Your Ref: OWPC20539
Our Ref: AW/259/18/PL 03-09-2018
Please ask for:
Mr S Davis

13th November 2018

1 No. dwelling.
10 Barrack Lane Aldwick

Thank you for your internet representation made on 12th November 2018 which has been recorded as '**no objection**' with the comments as follows:

Block Plan 1 : 500

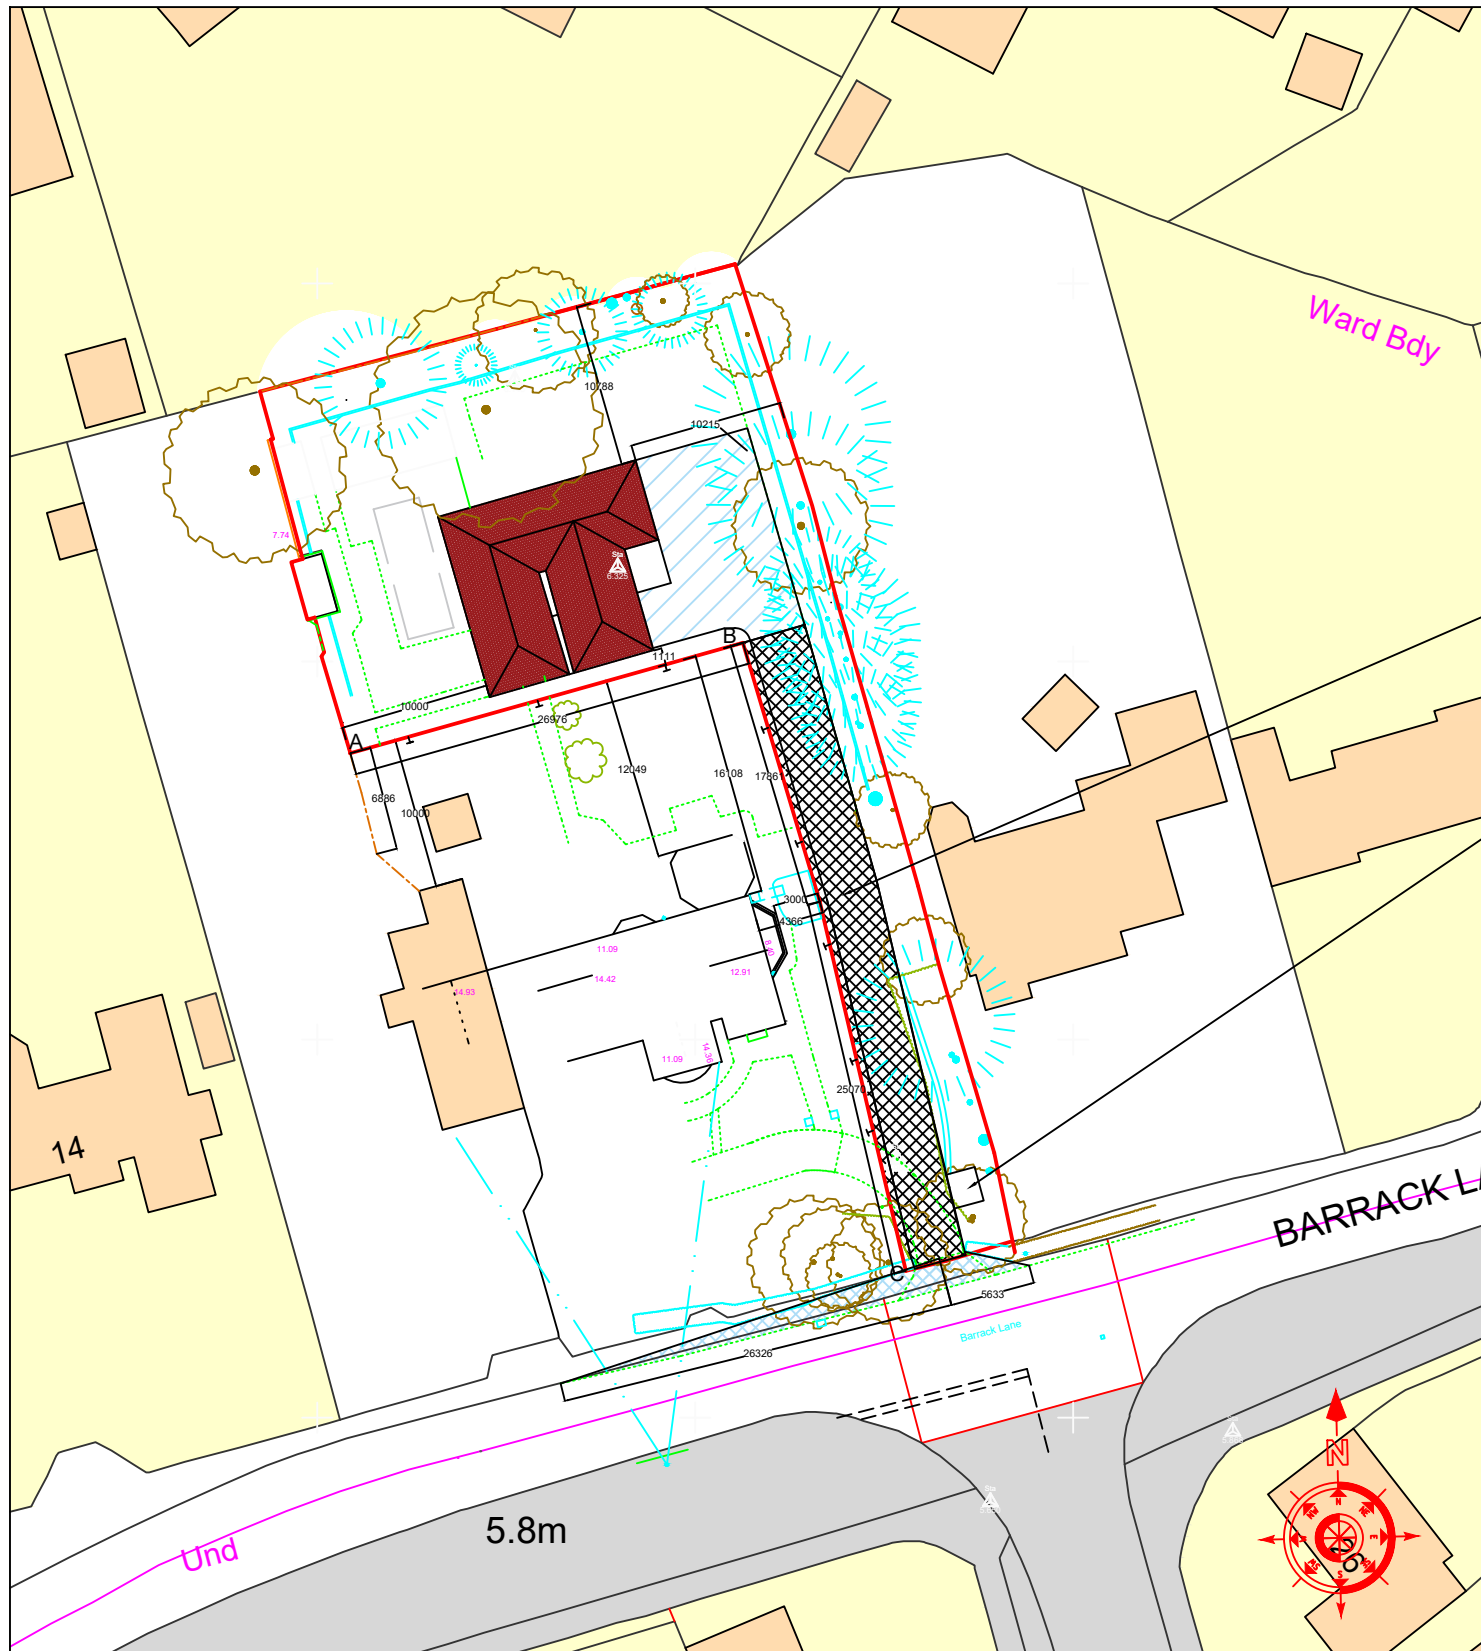
*If the application is successful, I would be grateful if conditions could be imposed to remove General Permitted Development Rights to this build.
This would ensure that my privacy is not eroded by potential additions/extensions and loft conversions/roof windows and lights in the future.
Looking at the site plan, the roof ridges at the same height do not correspond with the elevations indicating ridges at a different height.*
